Our ref: MP10_0057
File: 10/08342

**PROJECT APPLICATION FOR RESIDENTIAL DEVELOPMENT AT
132-138 KILLEATON STREET, ST IVES (MP10_0057)**

SCHEDULE 1 – DEPARTMENT OF PLANNING KEY ISSUES

BLOCK E ELEVATIONS

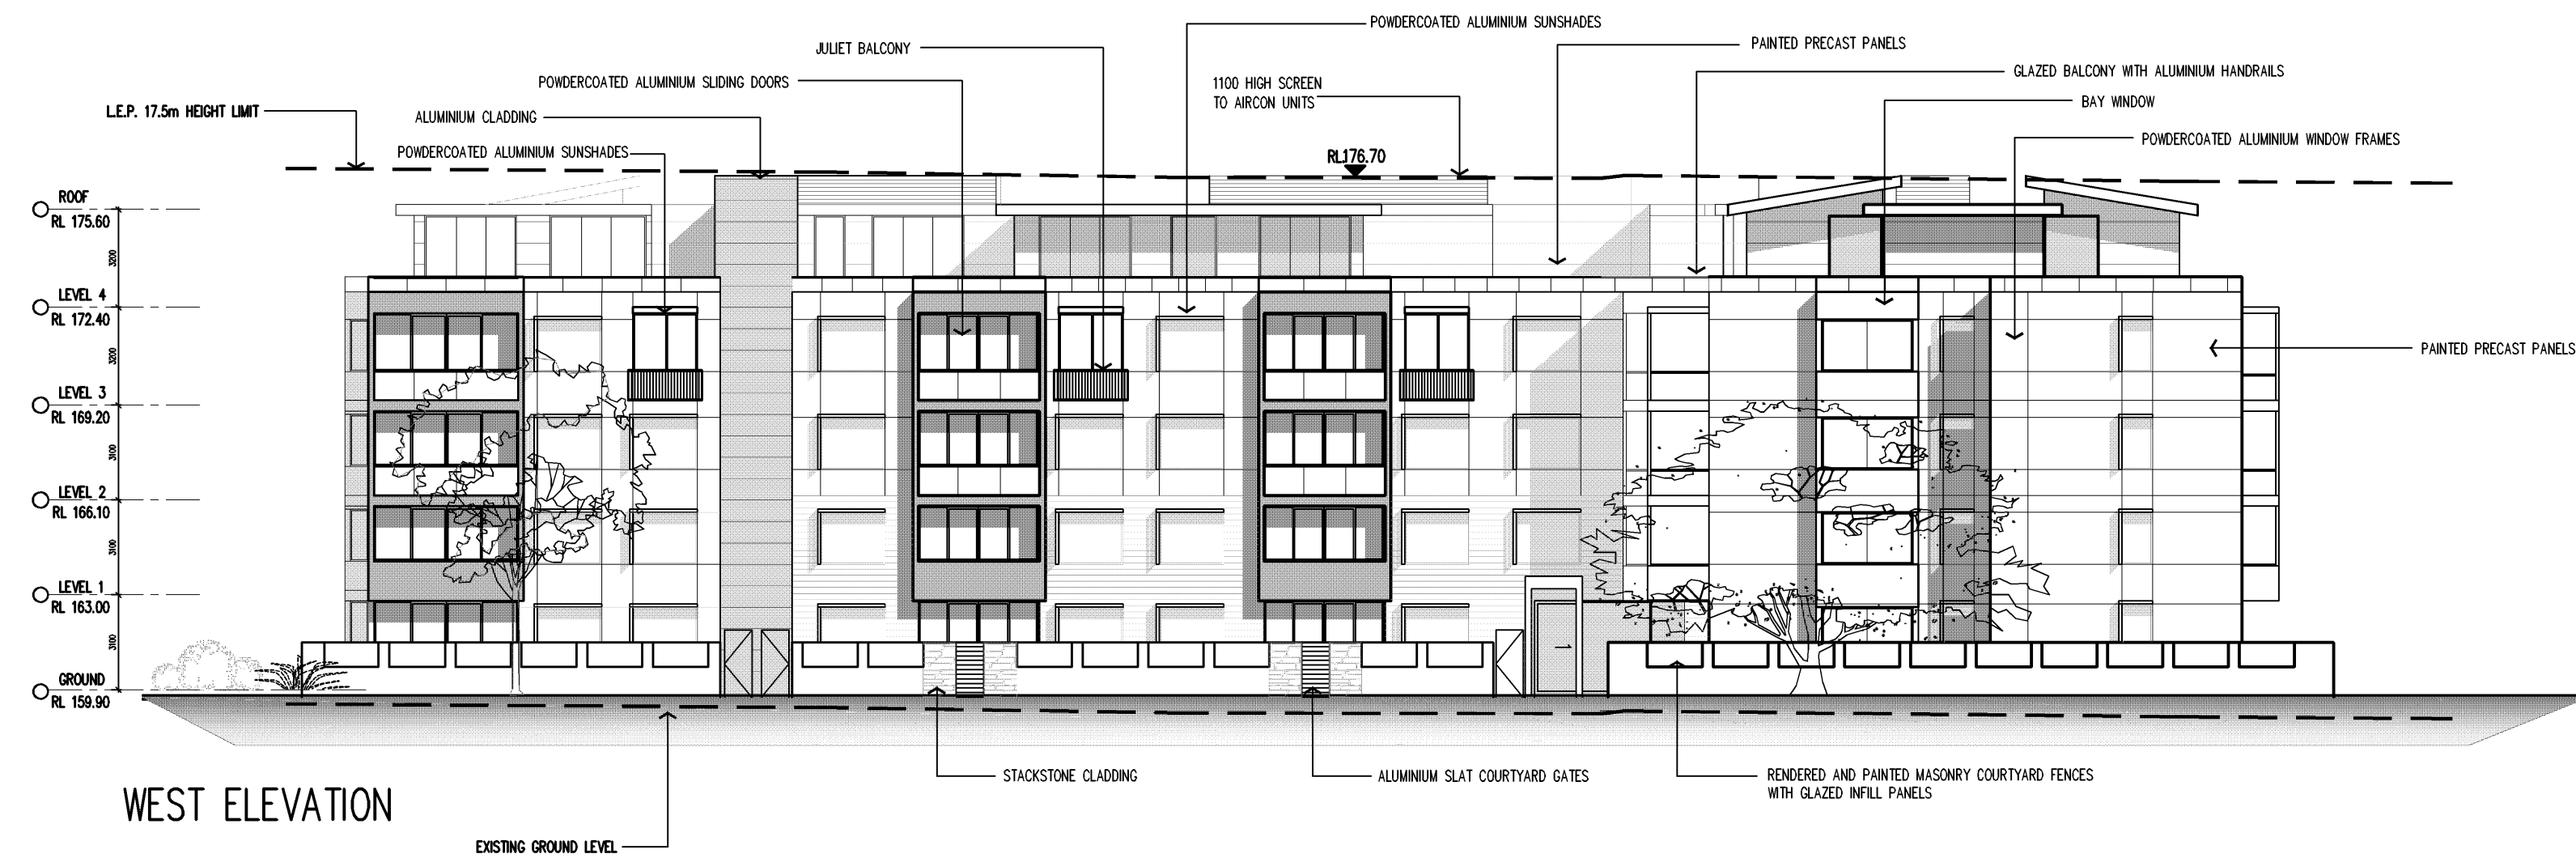
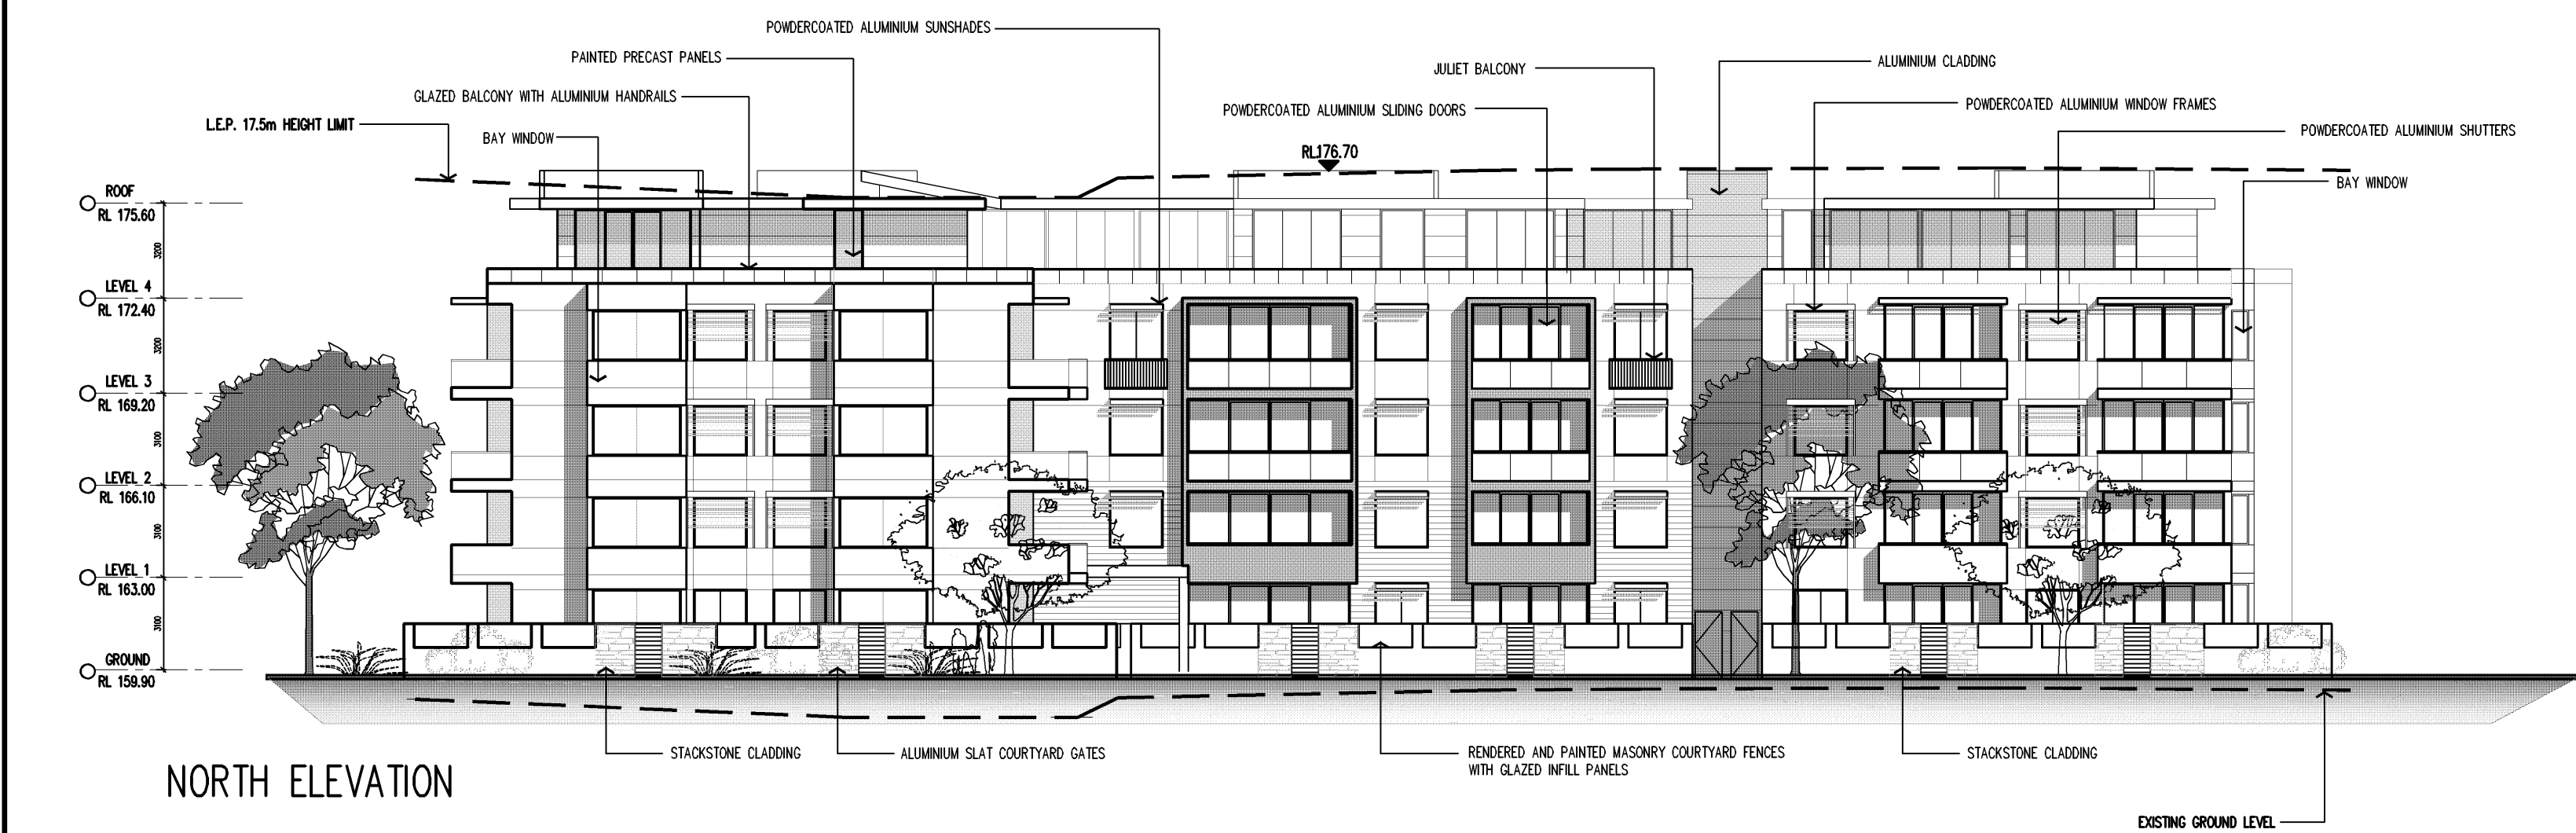
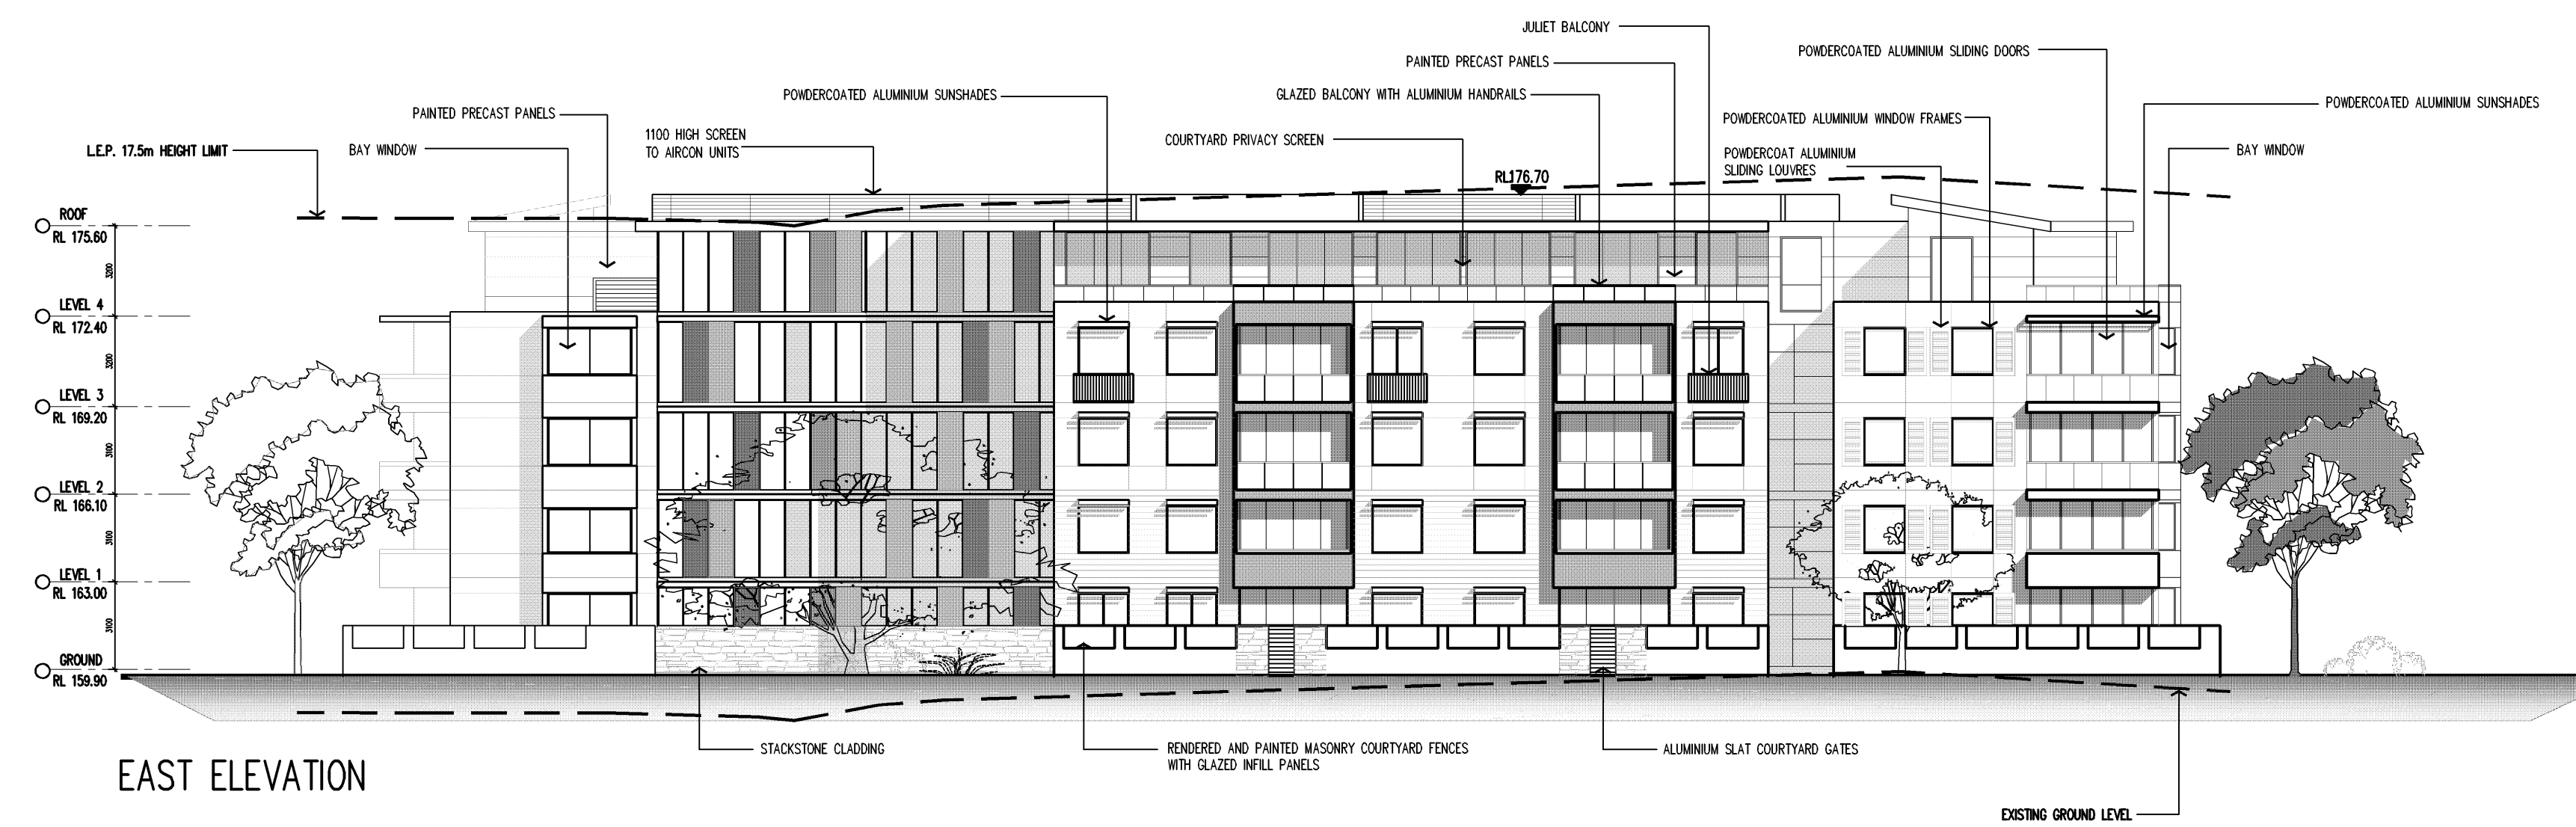
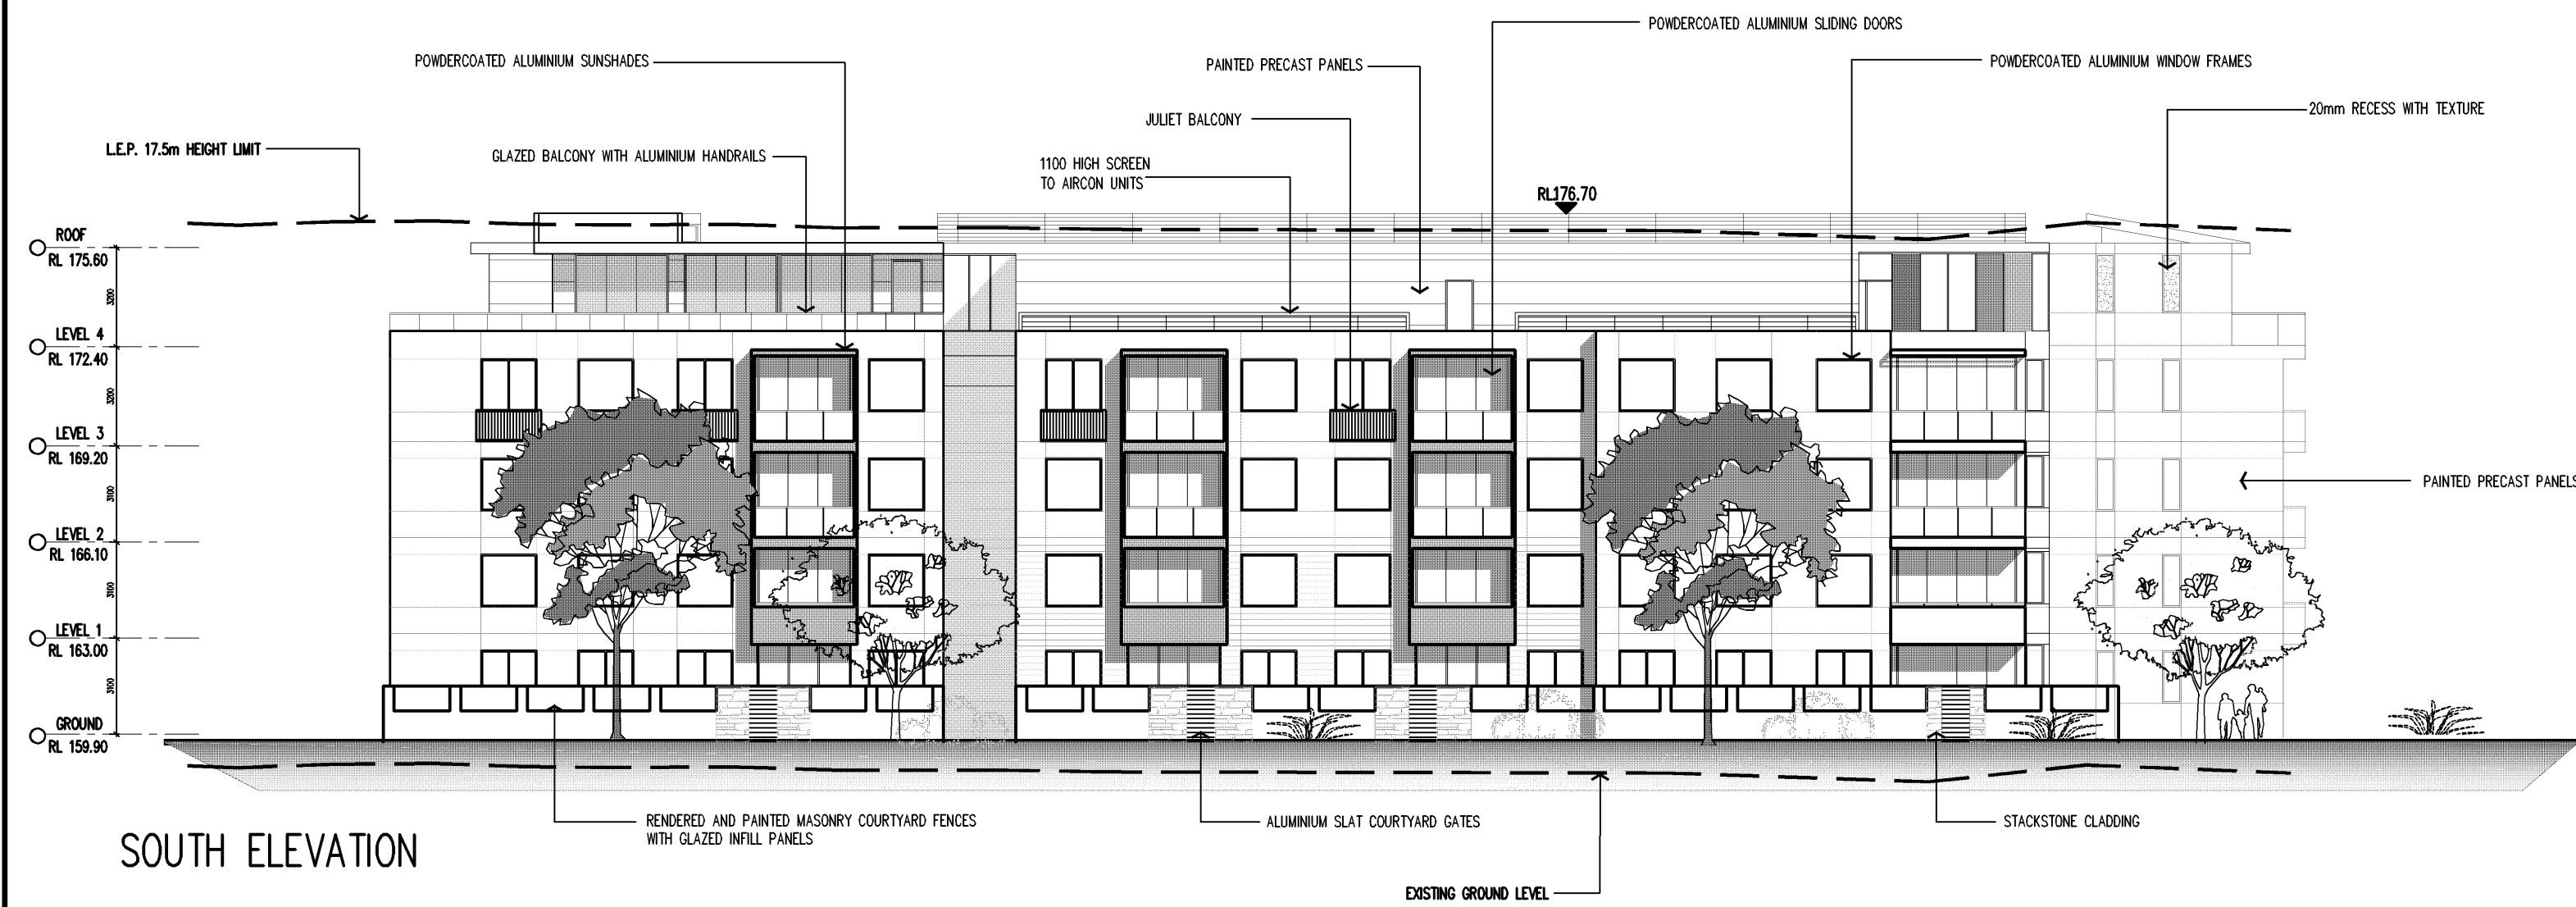
Consideration should be given to reducing the bulk and scale of buildings on the eastern part of the site given the interface impacts on the adjoining low-density properties to the east. Measures to reduce overshadowing and dominance impacts on these properties should be investigated. This analysis may involve options for potential redistribution of floor space across the site.
